OBJECTION

State Significant Development Application No: SSD-10300

Coffs Harbour Cultural and Civic Space

SECTION N-S

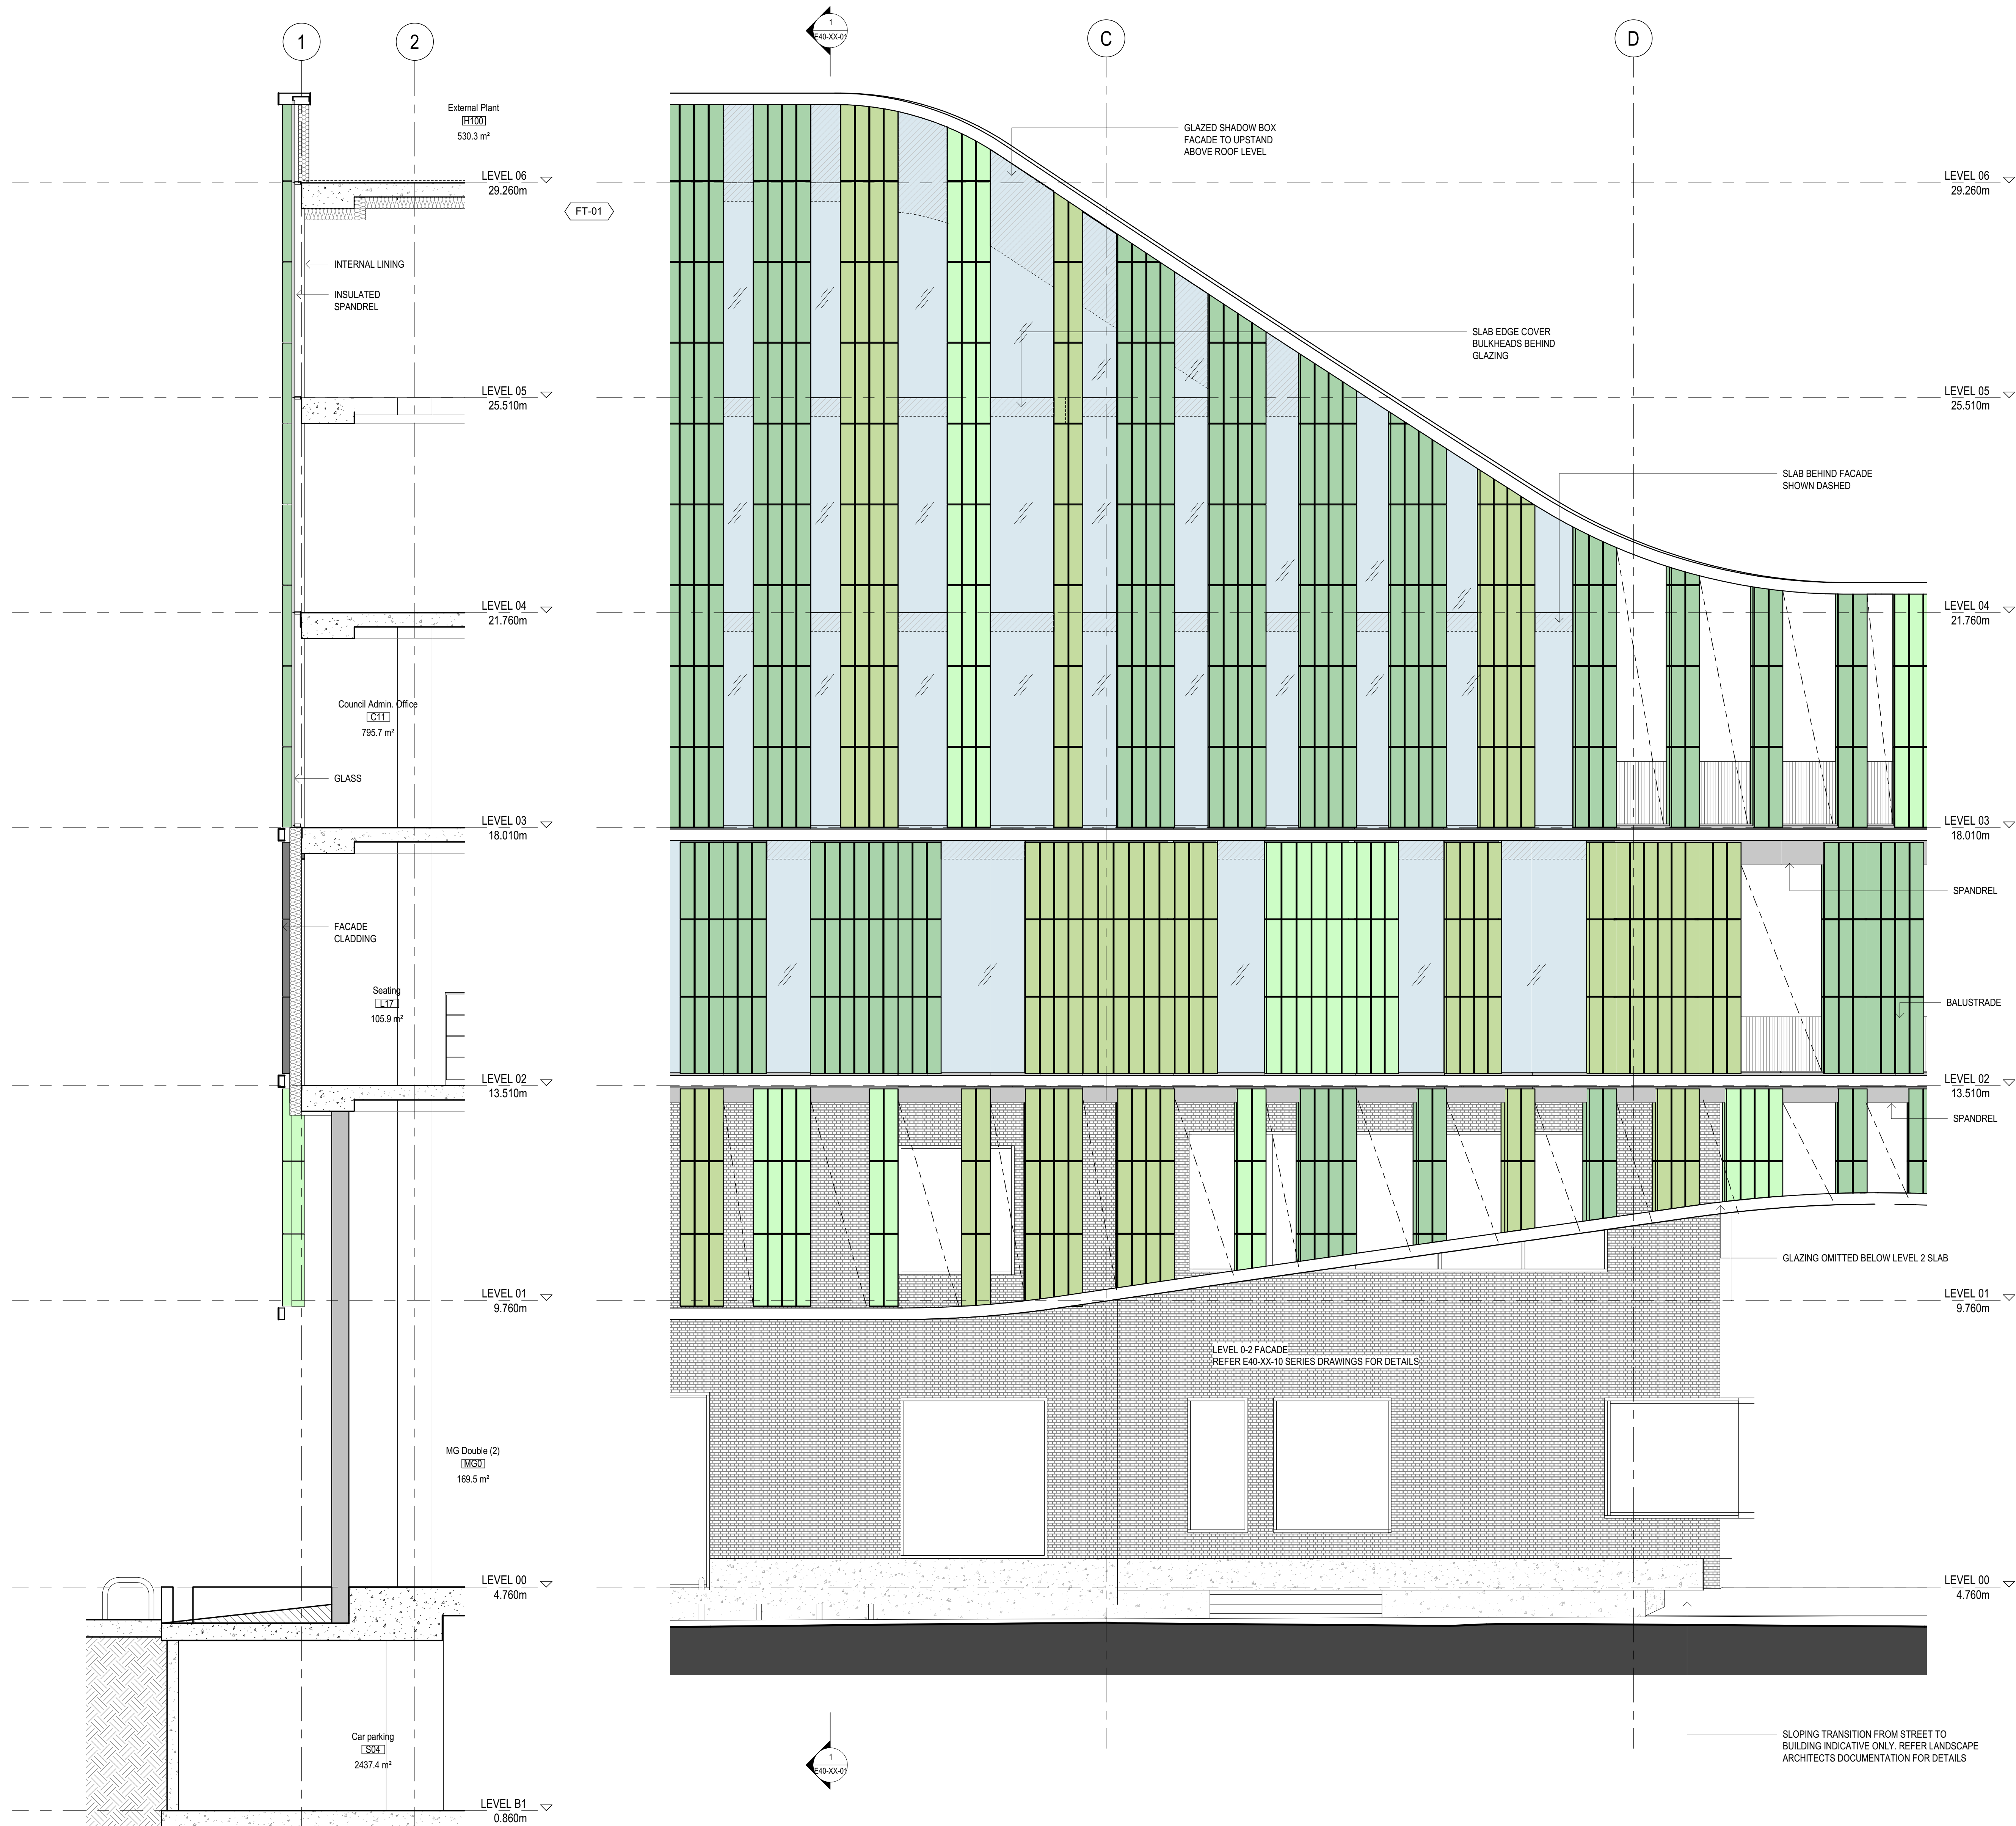
7. As a public building it fails to provide sufficient climate protection for pedestrians during storms and summer sun.
8. The building exceeds the height restriction of 28m set down in Council’s own planning controls. Council’s argument for variation is not satisfactorily justified and is not consistent with the objectives of the Environmental Planning and Assessment Act 1979, which requires the “the orderly and economic use and development of land”. Council should not receive preferential treatment.
